About the application

Application number: 2024/92167	
What is the application for?:	Variation of condition 1 (plans) of previous reserved matters approval 2017/9019
Address of the site or building:	Land off, Edgerton Road, Edgerton, Huddersfield, HD3 3AA
Postcode:	BD19 5LQ

User comments

Deveron Grove
Proposed Site Layout

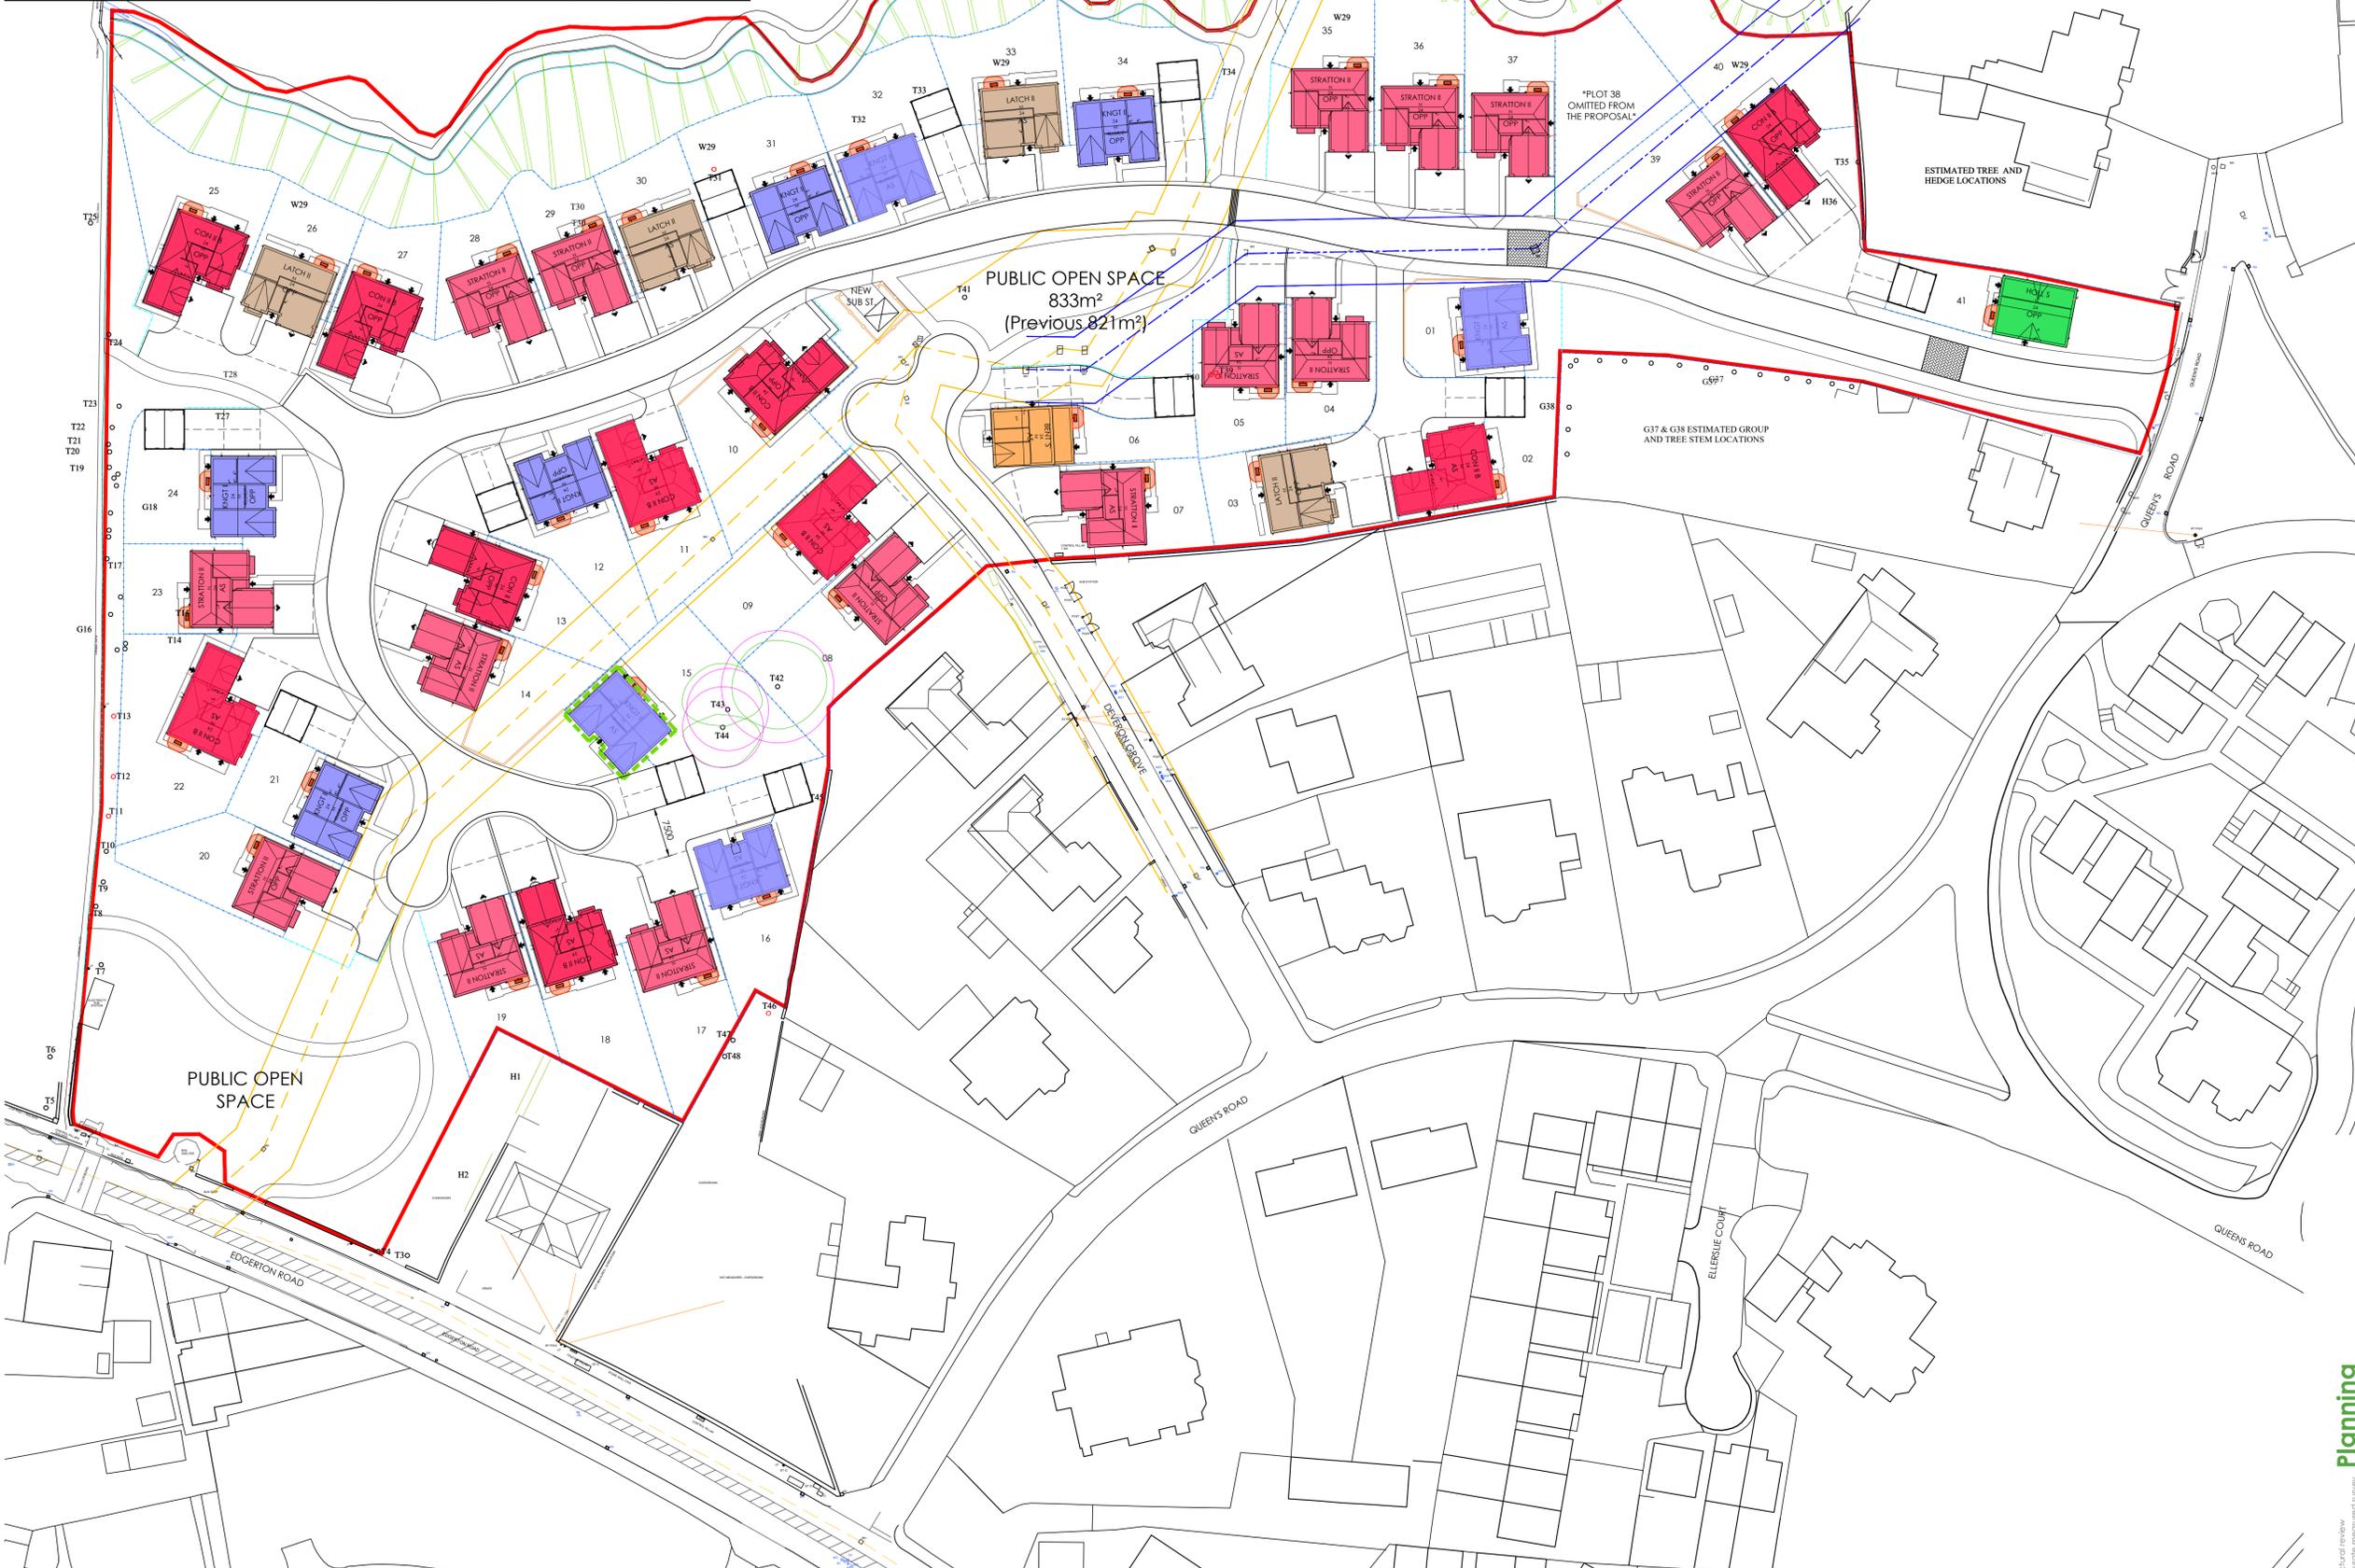
Edgerton is a conservation area, and it appears little thought has been given to ensuring the development fits into the surroundings and character of the area. The house styles and the layout is cramped and at odds with the existing historic layout of the houses around Queens Road, which is dominated by plots that are more spacious, and an abundance of ancient trees. This development crams houses together and removes much of the wildlife habitat and protected trees, which make the Edgerton area such a special historic and ecological asset to the town. The proposed building materials are not natural but more commercial cheaper versions, to maximise profit for the developer.

The site is not at all suitable for the proposed number of houses; Clayton Fields is an area, which absorbs a lot of water, which then feeds into the Clayton Dyke system. If this area is covered by a great deal of concrete, there will be an adverse impact on water run-off for residents around this area and little to absorb the dyke water on flooding. There are huge underground, concrete sewage pipes and storm drain structures on the site. I am surprised that Kirklees Flood Risk Management & Drainage acting as Lead Local Flood Authority has no comments as the land frequently floods and can be extremely boggy all year round. This is evident with numerous ponds forming and water reeds growing. It would be very expensive to prevent flooding on this site and the developer does not seem to mention or attempt to address this issue in the plans.

There are problems with accessing the site. Not only is the proposed main access to the houses impractical, but will also lead to a highway hazard, as Queen's Road and Murray Road are narrow, with narrow pavements and sharp bends. However, it is also dangerous for more traffic to access the site via Deveron Grove as this road sits on the sharp bend of Queens's road, with several driveways that exit on to this part of Queen's Road. All heavy plant and machinery will also need to negotiate the triangle of historic trees at the bottom of Queen's Road when accessing the site. Plant and machinery cannot use Deveron Grove. The junction of Deveron Grove is on to the sharp narrow bend of Queens Road, which results in Deveron Grove being of an angle such that a few years ago, the last time heavy plant tried to access the site using Deveron Grove to replace storm drains, part of the high stone walls were damaged. There is not an adequate turning area and coupled with the sharp blind bend it will be extremely dangerous for all motorists, cyclists and pedestrians, and even more impossible for those living on Queens's road to exit their properties safely. Before any work could ever be contemplated there need to be a detailed review of the suitability of site access arrangements, which does not feature at all in these plans.
